HYDROLOGY SECTION PROJ. NO. 115

CONFERENCE RECAP

SUBJECT: Woodward West

REF: Neurosurgical Offices (Woodward West) Dated 6/17/83 (J15-D16)

GRADING & DRAINAGE PLAN
NEUROSURGICAL OFFICES

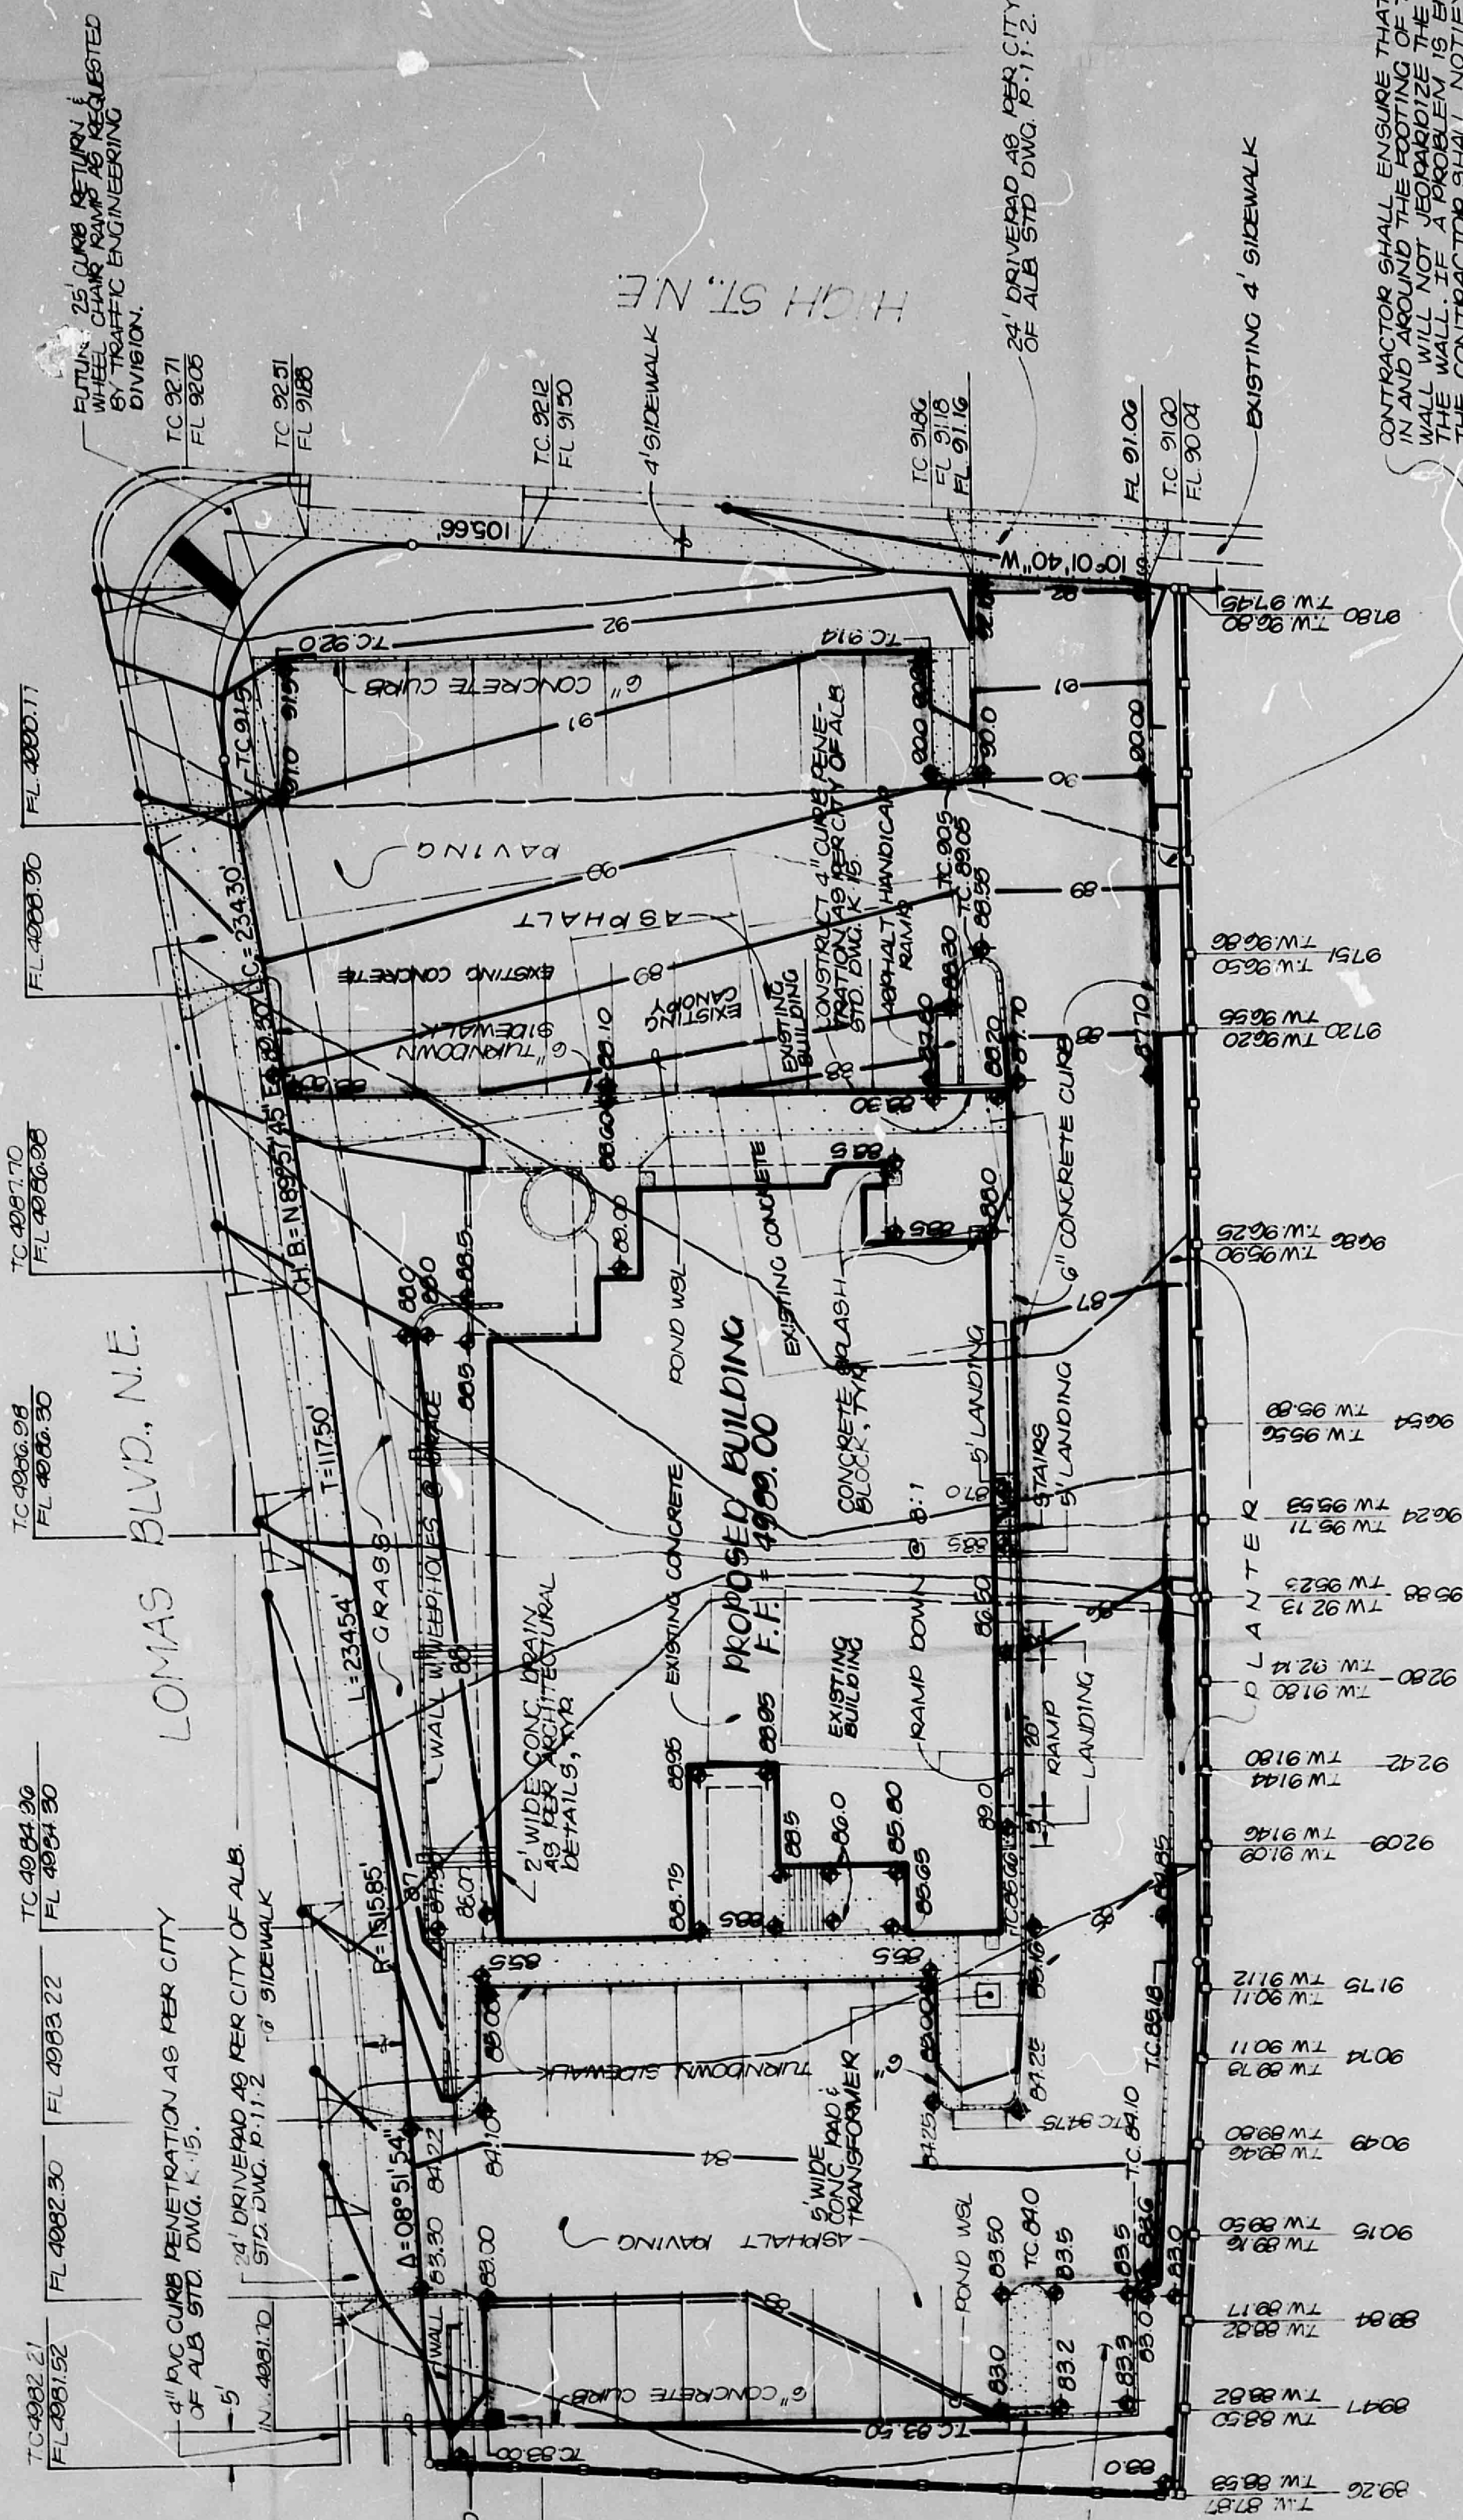
1. Flooding occurs downstream \Rightarrow
controlled release required

2. Runoff should be routed
through landscaped areas if
possible

3. Need to investigate parking/ponding
combination - depth in parking should
not exceed .5'

4. Drainage plan appropriate

The revised drainage plan satisfies my comments; therefore, this plan is approved.
